Walnut Bank, Bell St, Hornton. OX15 6DB - 14/5/21

Ref 21/00517/F – Wroxton MX Track

Reference: Landscape and Visual Impact Assessment – two documents, dated 1 April 2021

Viewpoint Location 5: Bell Road

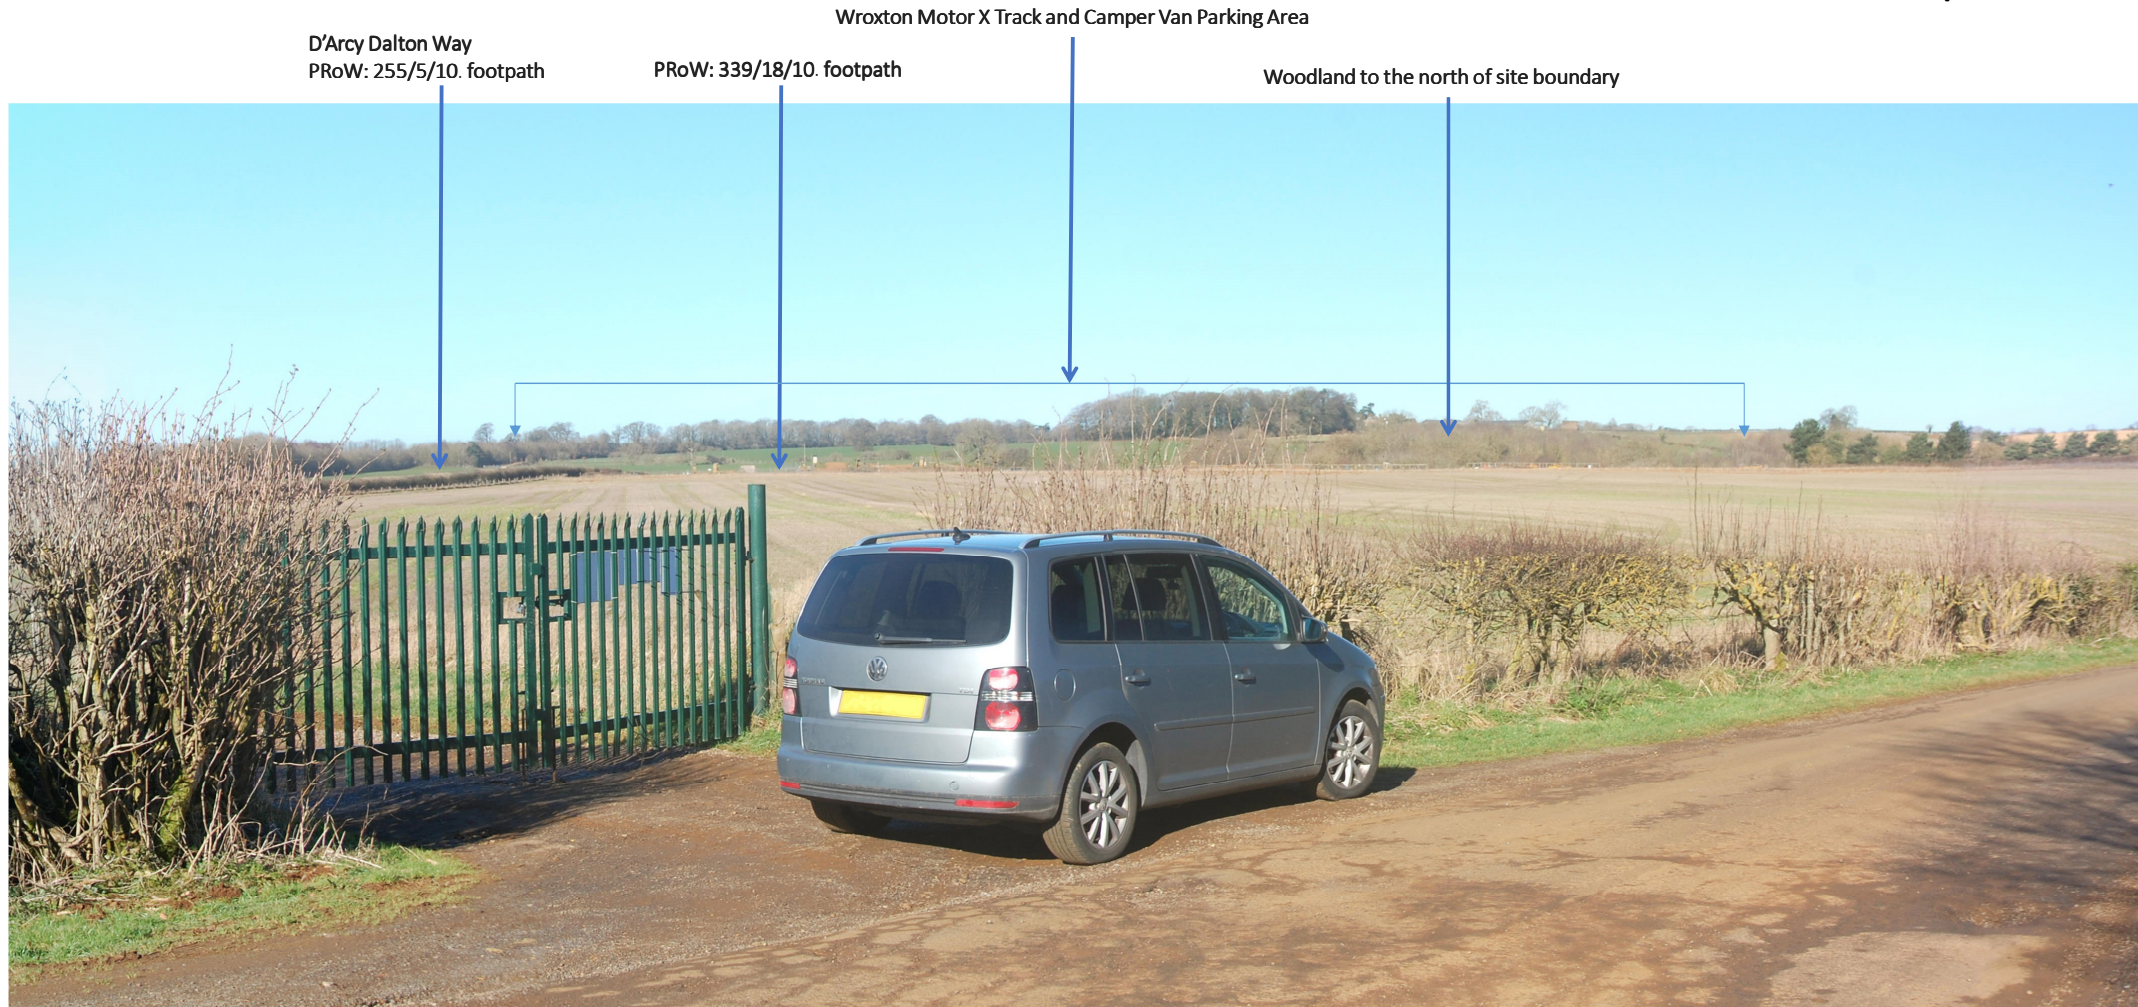
“Motor X Track – The track is an established feature in the local landscape and the majority of the track is located in the ‘lower’ parts of the field.”

Mr Steele fails to understand that it is the many new high points which are the cause of so many problems: the noise created from 40+ machines revving before the start and racing over triple jumps and the like – higher than the surrounding land, revving at full throttle.

This Viewpoint at location 5 is conveniently taken by the entrance gate where anyone driving is focussed on the bend in the narrow, pot-holed, lane not the landscape to the left.

If you choose to move 130 yards back up the road the view is vastly different. I took the following picture from my car on 13/5/21, but you can’t see this from Somerset!
